25.10.18

Sydney Metro Martin Place Station Precinct – Amending Stage 1 Concept Proposal (south site building envelope) Sydney Metro Martin Place Station Precinct. Response to submission by the City of Sydney Council 24.09.18

Figure 54 – Proposed South OSD tower building envelope, south elevation (amendment clouded red)

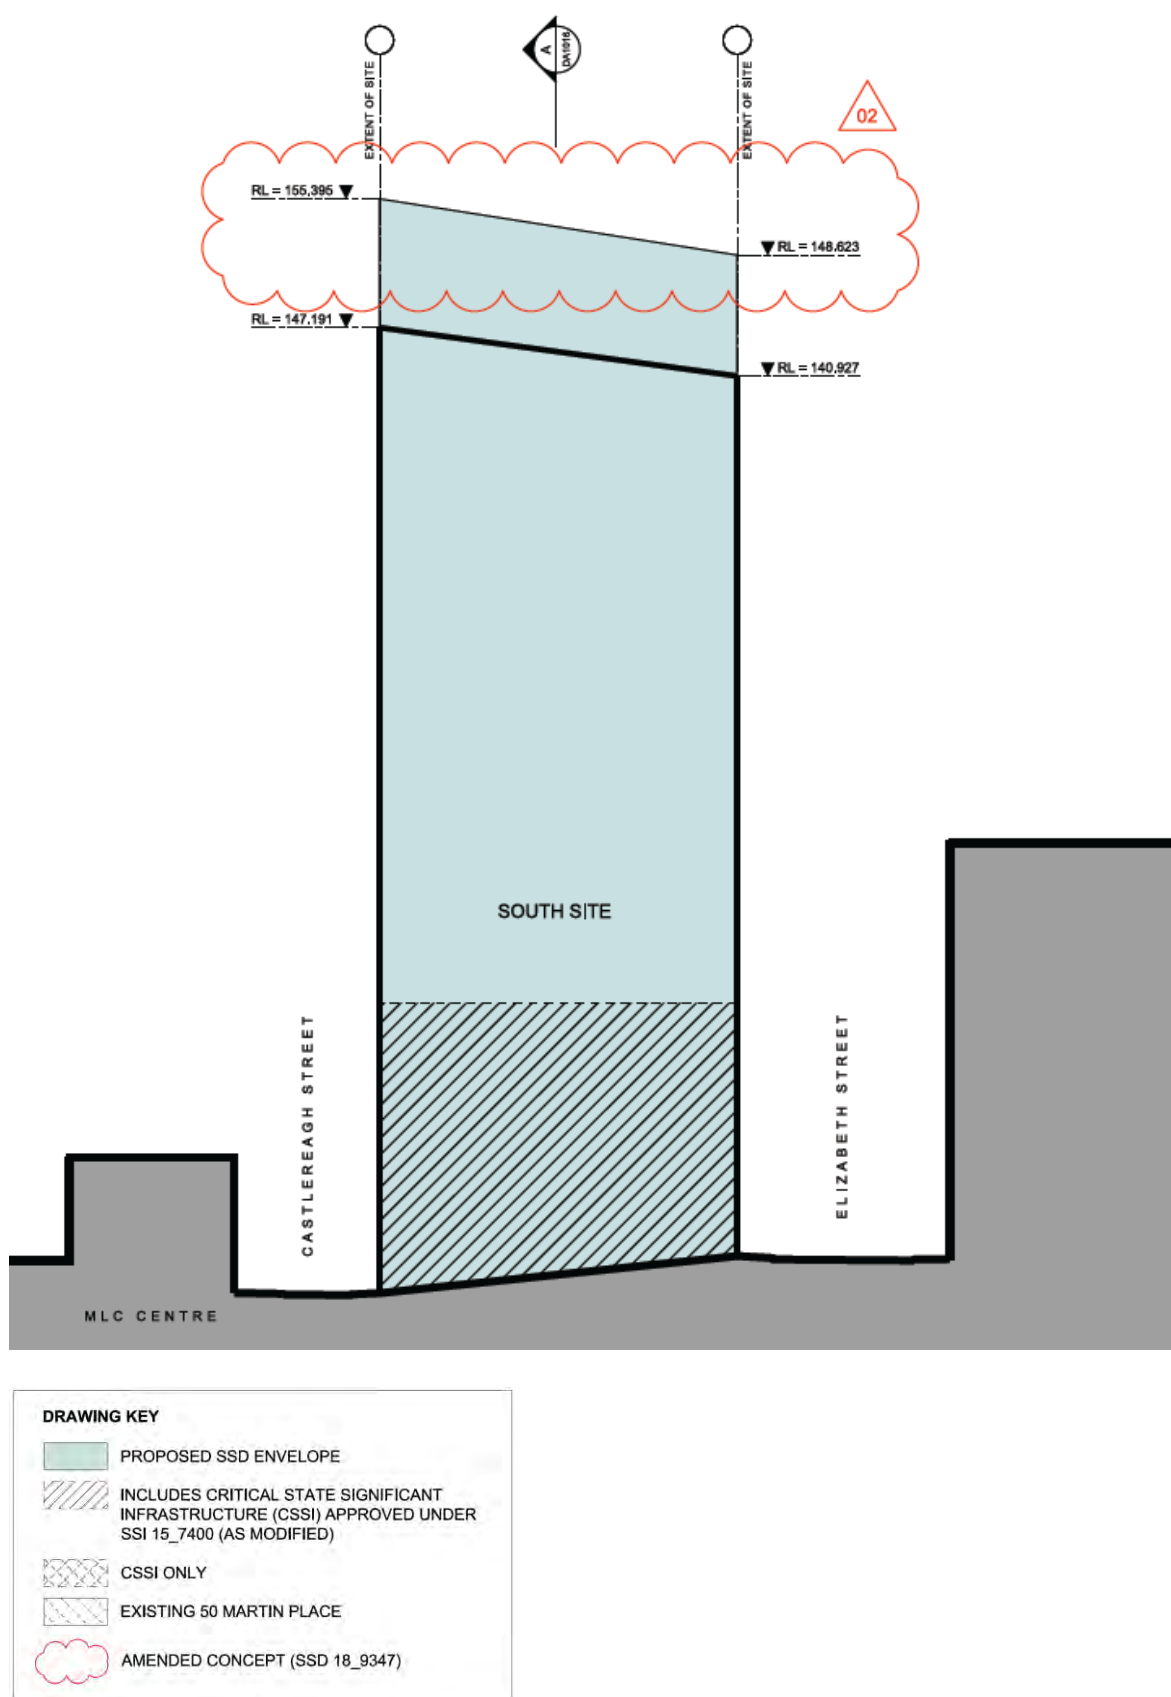
In addition to these concerns they are proposing that 'building returns be incorporated in the southern corners of the envelope as a transition to the adjoining development to the south above the podium height. CoS suggest that this would in part assist in achieving the outcome of the PACs' advice of reinforcing the importance of the urban character and integrity of Martin Place and the associated city blocks. They recommend a return of 8m x 8m for each corner of the South Tower above a nominal 45m podium height.

The introduction of recesses to the southern corners of the south tower as suggested by the CoS detrimentally affects the implementation of this principle by weakening the definition of this threshold edge.

When the 8x8m corner recess is implemented, it implies that this setback is extended to the south. As the existing building to the south currently has a less than an 8m setback, the implementation of the 8x8 corner recess would create a potentially awkward built form relationship between the two buildings. It also increases the likelihood that the future redevelopment of the site to the south would constitute a 'refurbishment' of the existing built form, rather than a new built form, in order to protect the current built form footprint and retain the current setbacks.

If the 8x8m recess is implemented it implies a podium height to these buildings to the south and that this podium height be the same as both 50 Martin Place and the podium on the South Site, reducing the distinctiveness of Martin Place in the context of its streetscapes.

The introduction of a recess to the southern corners of the south tower detrimentally effects the implementation of this principle.

In the view of Tzannes the introduction of the proposed recesses in the southern corners of the proposed built form is detrimental to the City's ambition to reinforce the importance of the urban character and integrity of Martin Place and the associated city blocks. They are not supported by the previously presented urban design analysis or the approved Consolidated Design Guidelines. For the reasons set out in these reports and above we reiterate our view that the current proposal provides the greatest opportunity to reinforce the importance of the urban character and integrity of Martin Place and the associated city blocks.
